**Re: Addendum 1 – Subfloor Drainage System Diagram and Additional
Subsurface Information – Proposed Development – 100 Bareille Snow
Street, Ottawa, Ontario**
Cambium Reference: 24896-001 Rev.1

Cambium Inc. (Cambium) was requested by Wateridge Lifestyles Ltd. (the Client) to provide a diagram outlining the subfloor drainage system as outlined in the geotechnical investigation report (2026, July 16). In addition, Cambium advanced additional test holes at the site on March 20, 2026, as part of the hydrogeological investigation, including additional groundwater monitoring wells screened in the overburden soils. Rock probes were also advanced on the same day as the monitoring wells at the site to further delineate the bedrock depths.

This addendum provides a summary of the additional data and the requested diagram outlining the subfloor drainage system. The addendum to the report must be read in conjunction with the geotechnical report below:

TEST HOLE LOCATION PLAN

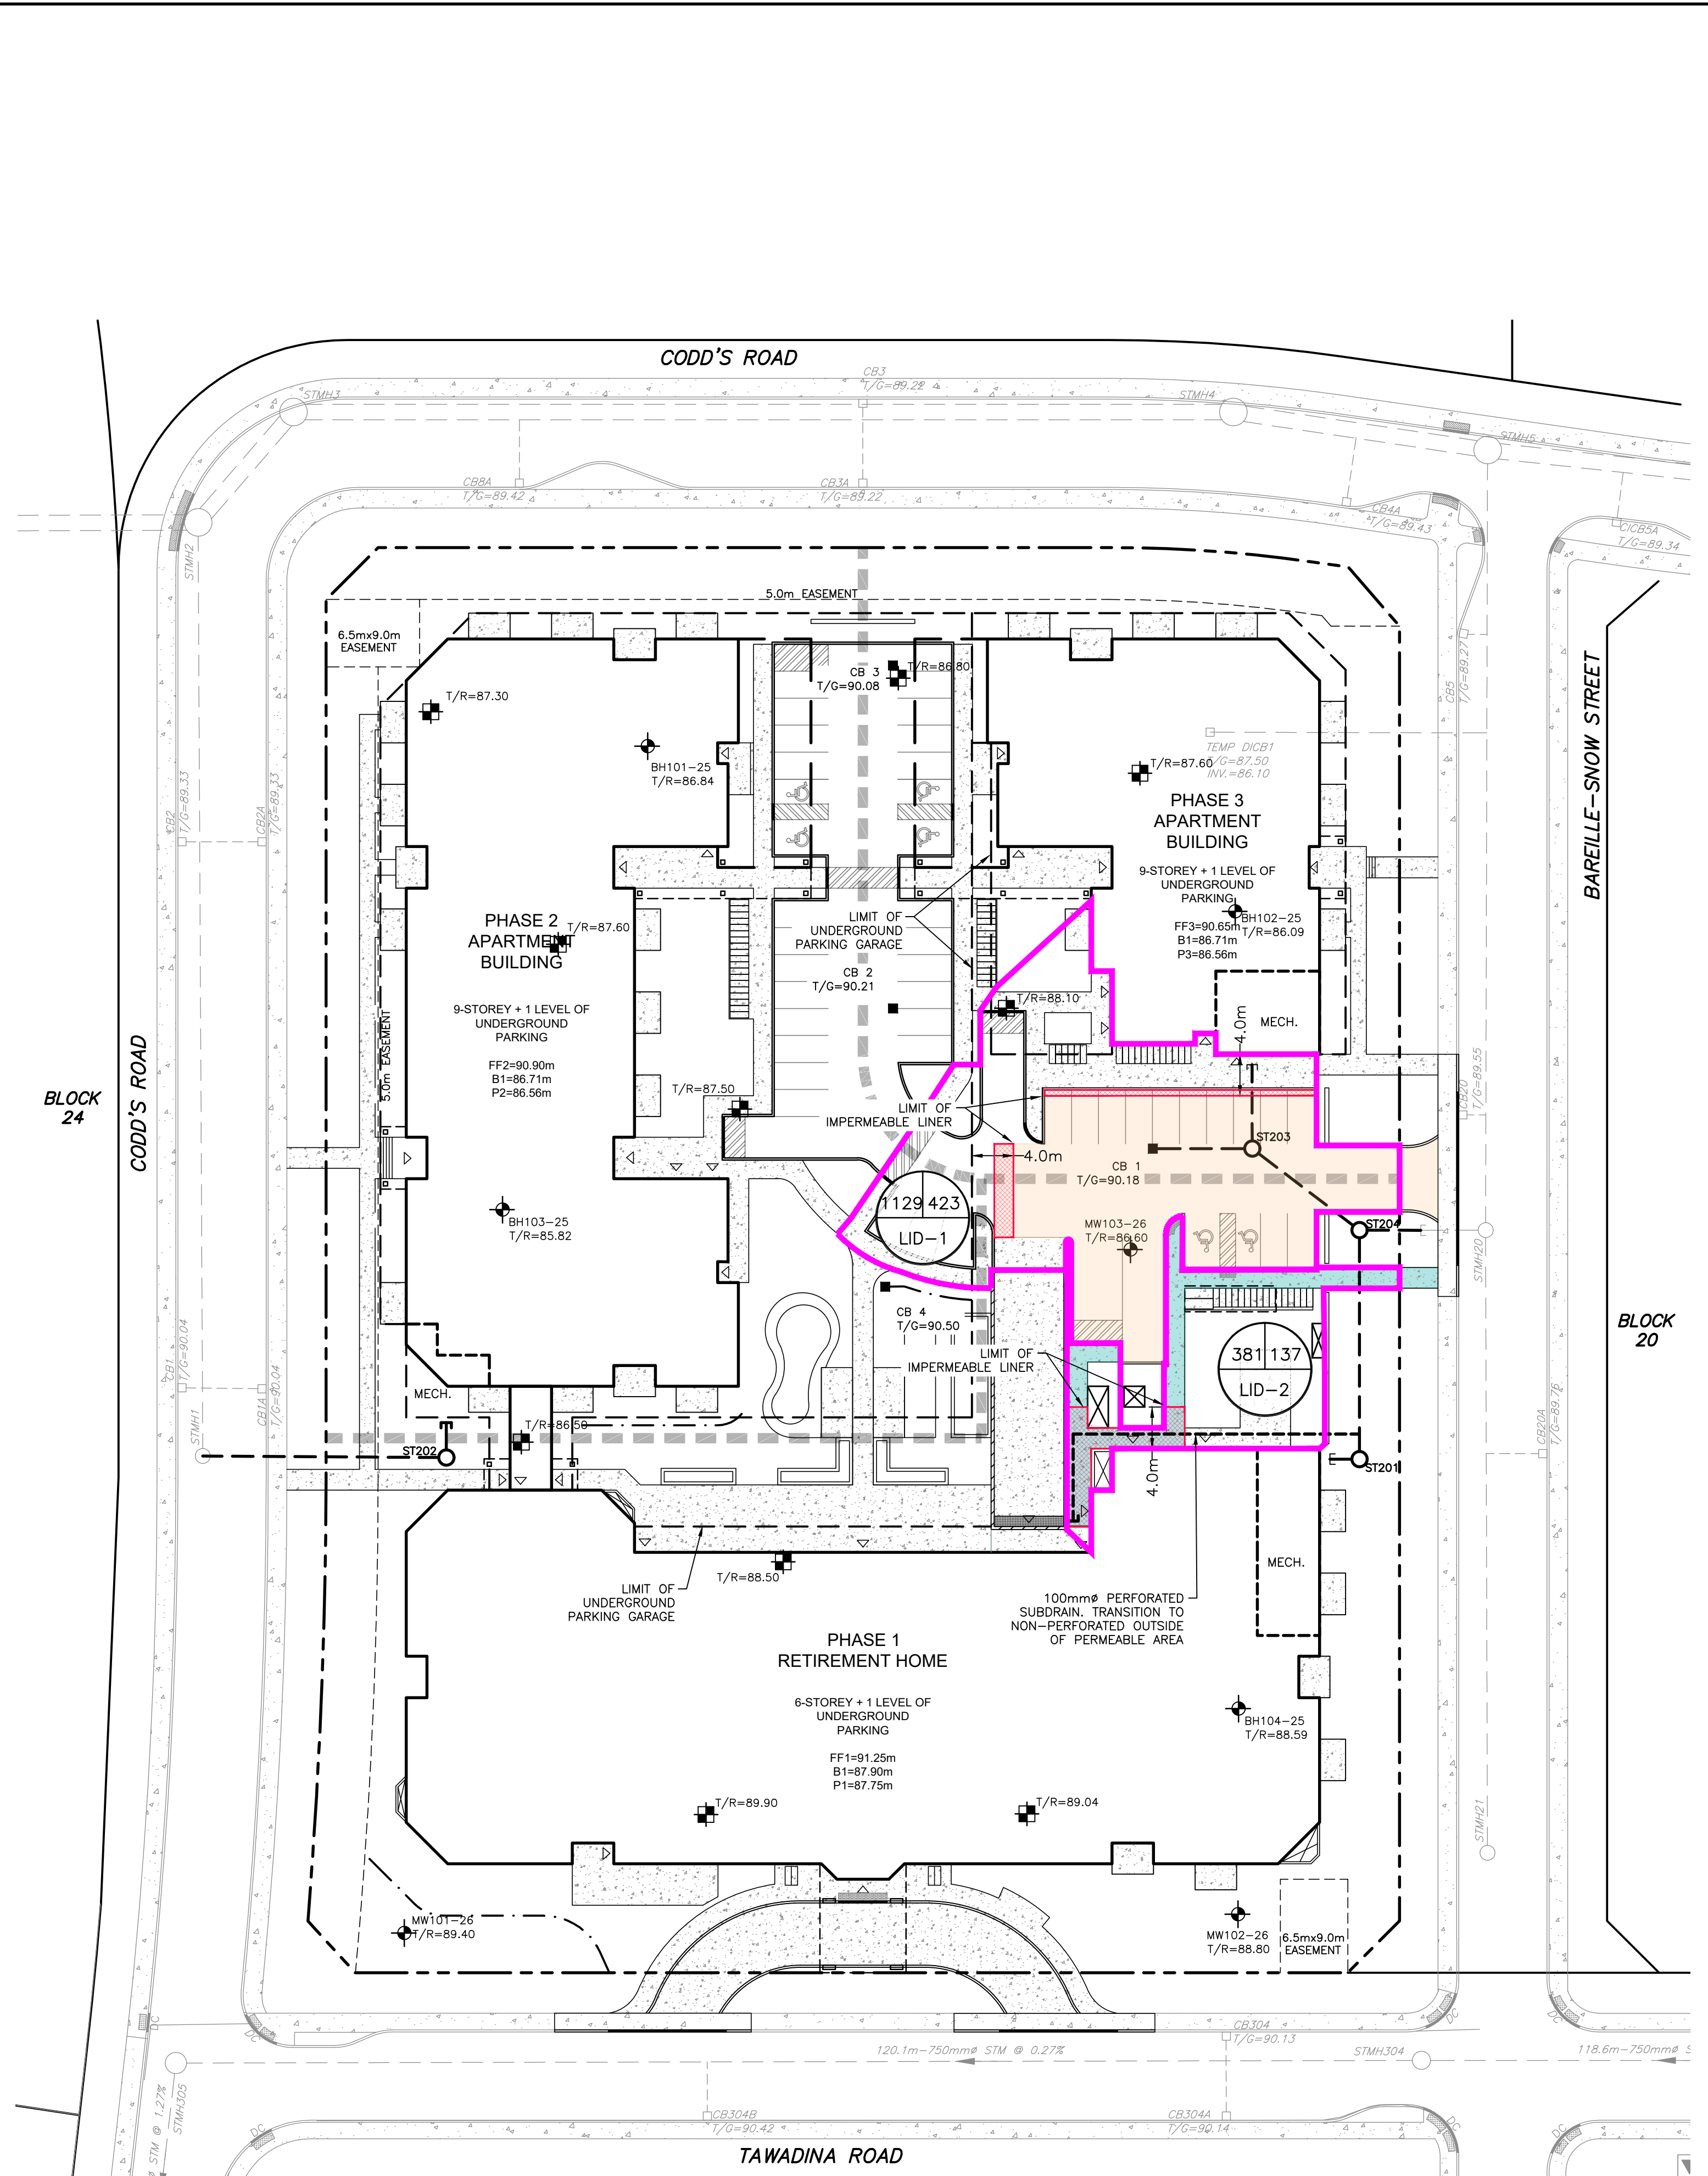
Cambium installed a total of 3 groundwater monitoring wells, numbered MW101-26 through MW103-26, and advanced a total of 6 rock probes, numbered RP201-26 through RP206-26 on March 20, 2026. Groundwater monitoring wells were installed as part of the ongoing hydrogeological investigation and rock probes were advanced to obtain additional data at the site. Details of the locations and depths to bedrock at these test holes are provided in Table 1 below. In addition

to the table, an updated “Figure 2 – Test Hole Location Plan” is attached following the text of this letter.
